Subject: FW: 7 Little Drive, Ferring, FG/94/20/HH

Please accept our formal objection herein to the planning application FG/94/20/HH.

For • Mr. & Mrs. K. King
D.R.G. • 19/14/3.A.
SCALE : 1/50. A.2019.
DATE : DEC. 2019.

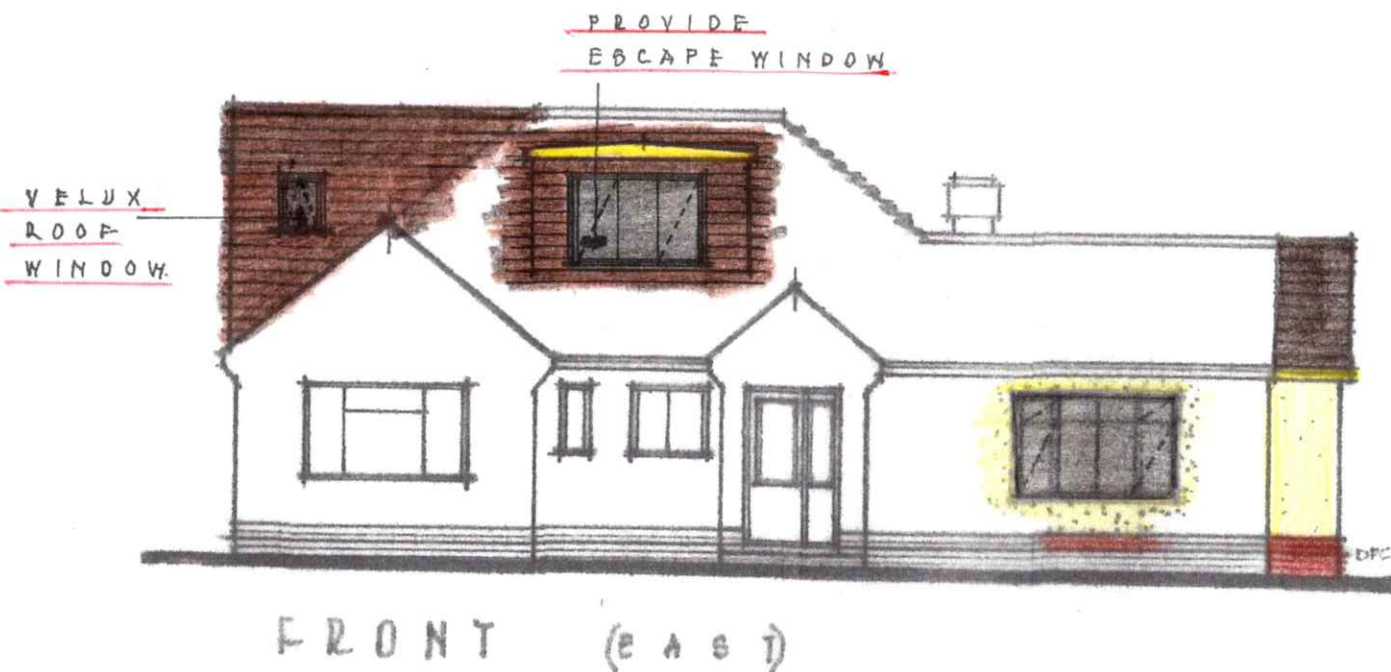
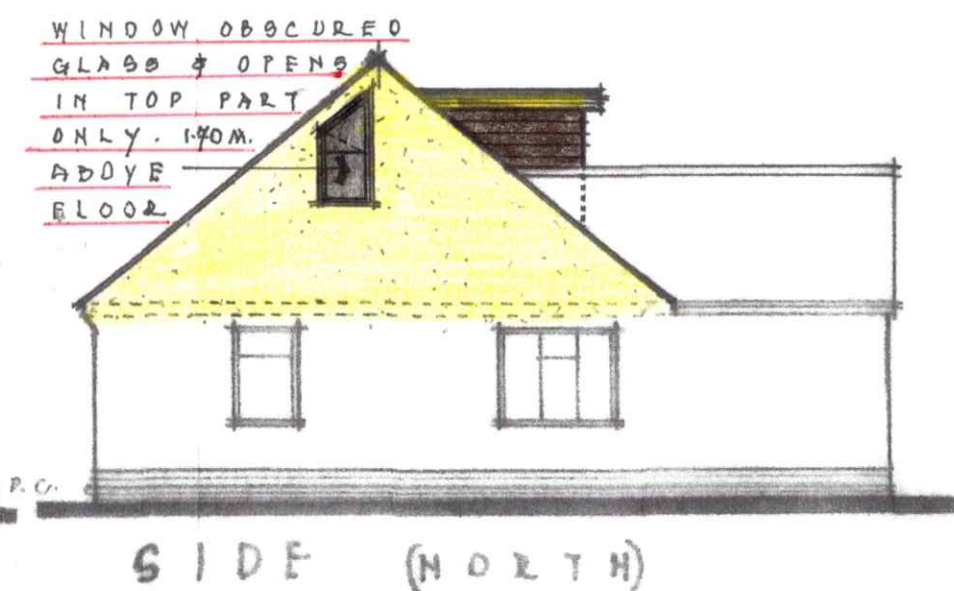
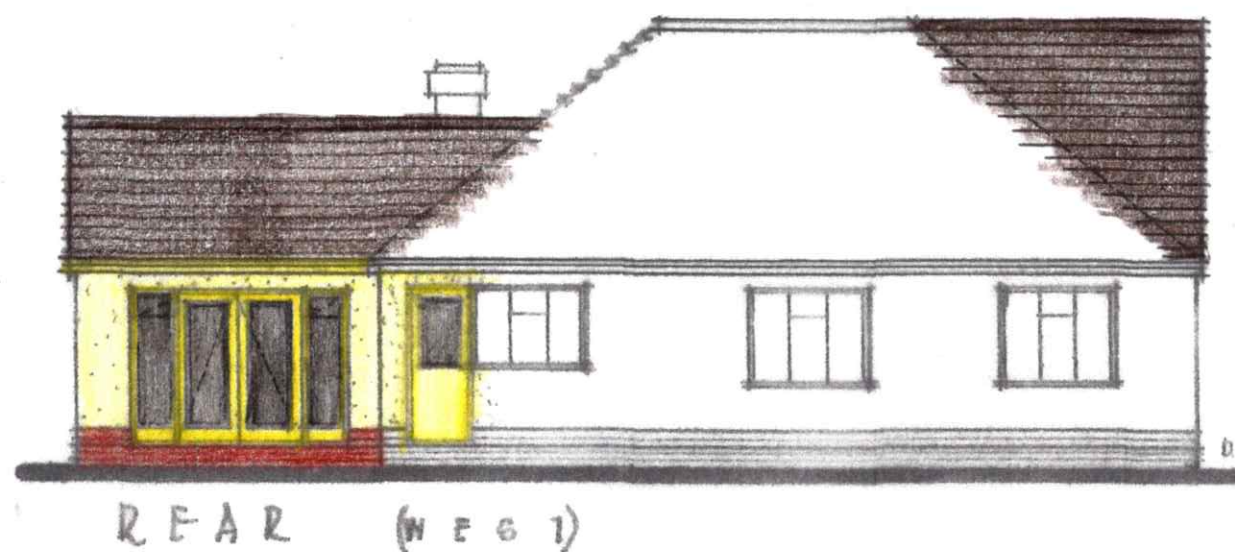
We have examined the plans submitted and would now like to formally object to the planning application of number 7 Little Drive due to the fact that the dormer in the front of the property is a direct invasion of our privacy.

We live at 11 Little Drive which sits on a corner plot positioned in front of number 7 Little Drive. The dormer will look directly into our back garden leaving no area where our family will be allowed any privacy; it also has direct sight into the master bedroom window and my daughter's bedroom requiring blinds to be drawn to maintain privacy and incurring a loss of light as a result. The front dormer will also peer directly into our side lounge window and is completely out of character for all neighbouring and adjacent bungalows in Little Drive.

We have lived in Little Drive for over five years and are aware there is a covenant on the bungalows which includes number 7, that does not allow windows being put into the roof. No other bungalows in Little Drive have put in dormer windows in their roof which significantly overlook and invade another bungalows privacy in this cul de sac, especially one that overlooks a neighbouring property to all primary aspects of their property, as it would do to 11 Little Drive.
